# CITY OF ALBUQUERQUE

**Re: Tiny Home Village – 8101 Zuni Rd. SE**  
**Erosion and Sediment Control Plan**  
**Engineer's Stamp Date 1/07/2020 (K19E138)**

Based upon the information provided in your submittal received 1/31/2020, the above referenced plan is approved to be included in the SWPPP and to apply for an ESC Permit/eNOI for Grading and Building Permit with the following conditions.

TEMPORARY SEDIMENT & EROSION CONTROL PLAN

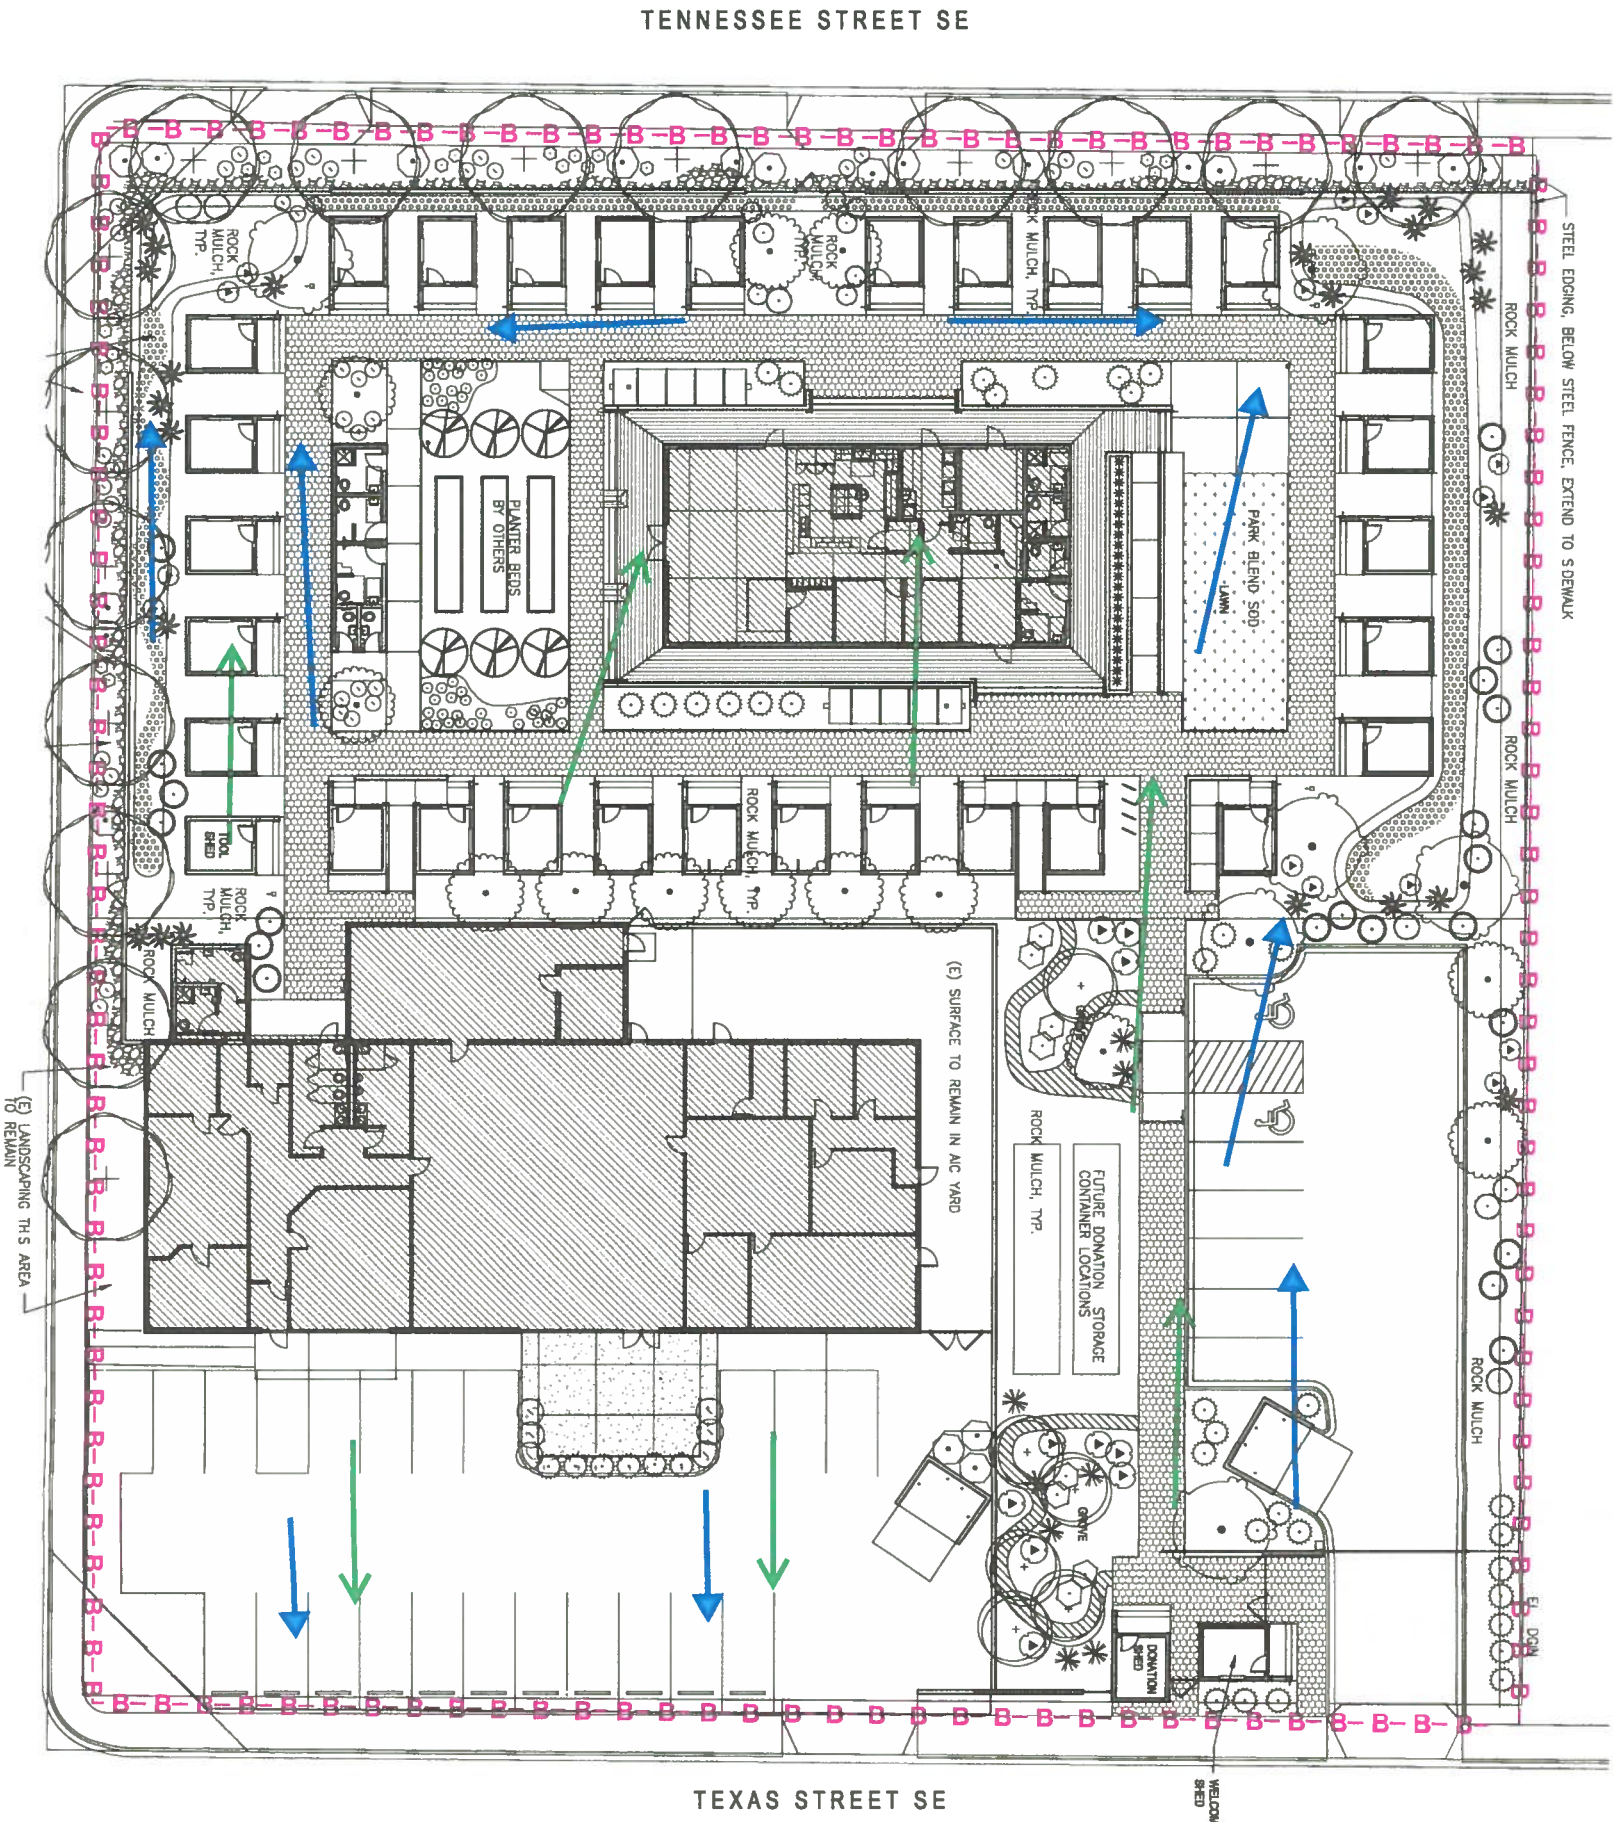
1. A Construction Entrance must be installed, preferably on Texas St., prior to the beginning of construction.
2. Inlet protection must be installed and maintained during construction within the public right of ways at the existing inlet in the southwest corner of the site.
